Consultation Response from KC, Highways Development Management (HDM)
2024/91242 Land north east of Shepley Road, Stocksmoor, Huddersfield, HD4 6XW
Erection of residential development (up to 50 dwellings) with associated access, parking, public open space, landscaping and infrastructure
Date Responded: 14/10/24 Responding Officer: A.Darwin Responding Ref: 12-33/18

RECOMMENDATION: HDM are unable to support the development proposals as this time in their current form.

Drawing No. AMA-20547-ATR006-2.4 Rev. P01

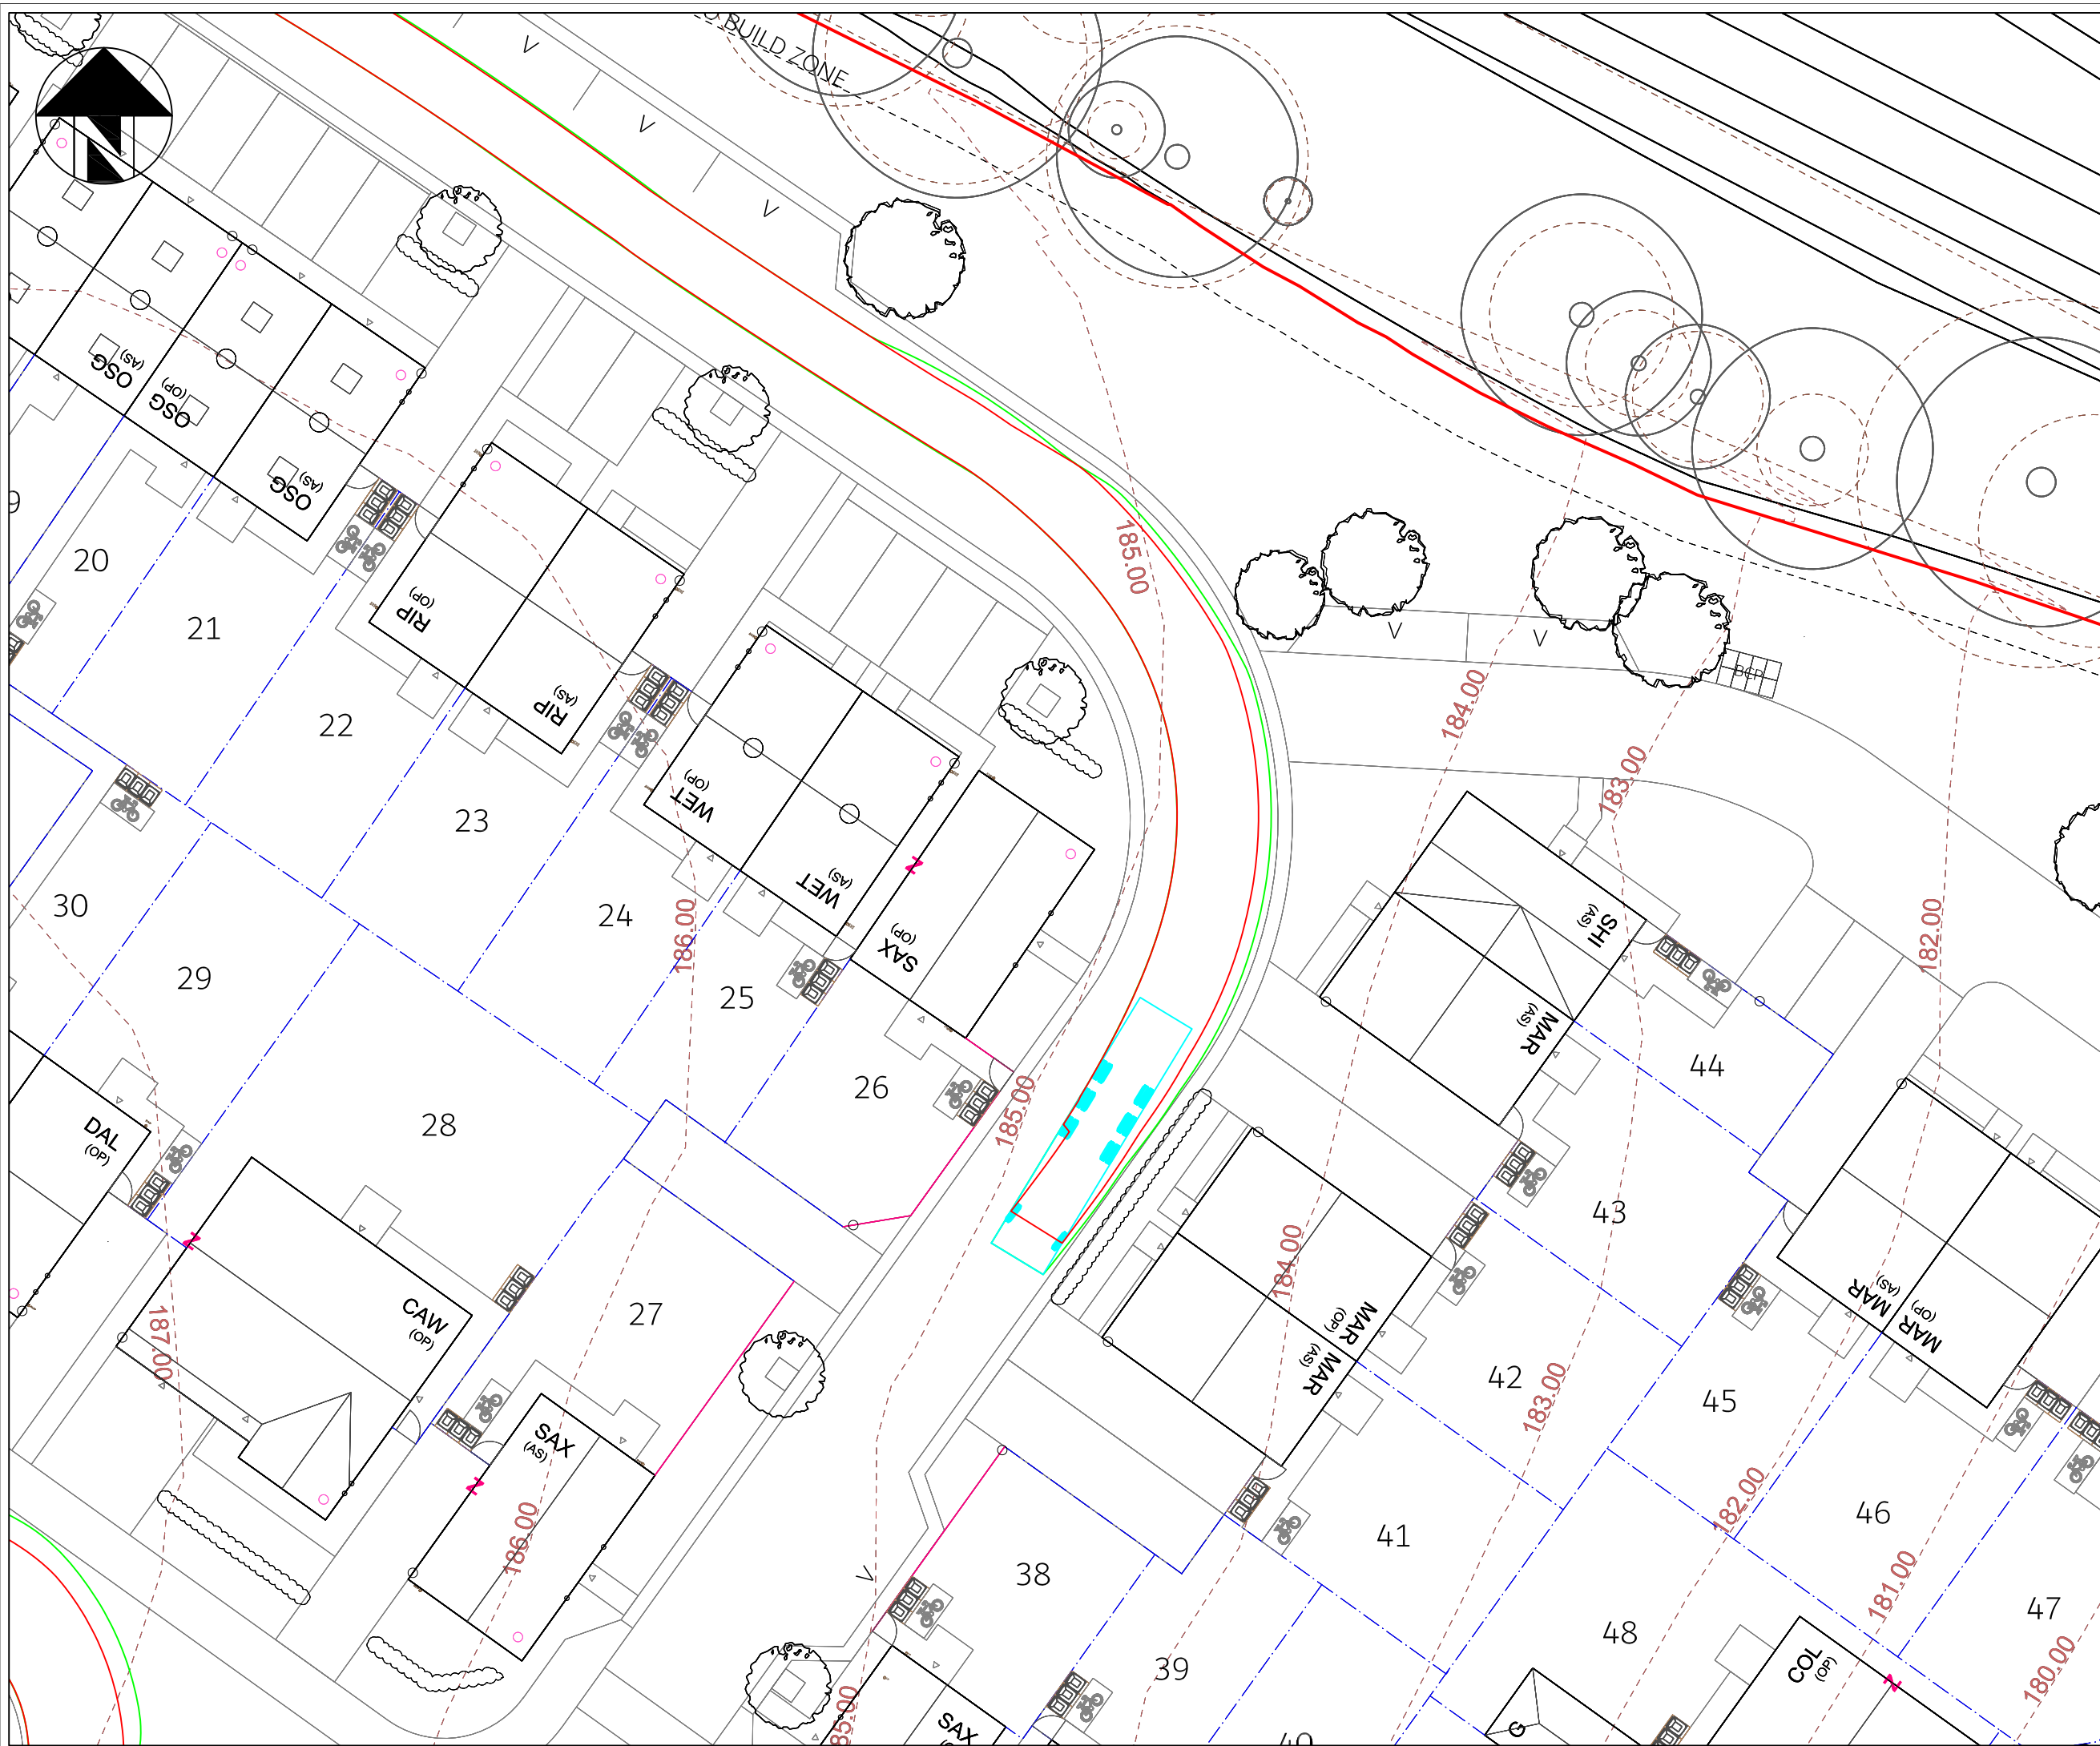
- To enable highway adoption, swept path analysis is required to demonstrate that a 11.85m refuse vehicle can pass an oncoming or parked family car throughout the layout, which is likely to require bend widening to accommodate these manoeuvres. This has not currently been demonstrated.

- The proposed turning head at the end of the shared surface street appears to have been checked with swept path analysis using stationary steering, which is not acceptable. Therefore, this needs to be rechecked without the use of stationary steering, which is likely to require the turning head to be enlarged (typically turning heads need to be circa 30m long to accommodate the Councils design refuse vehicle).
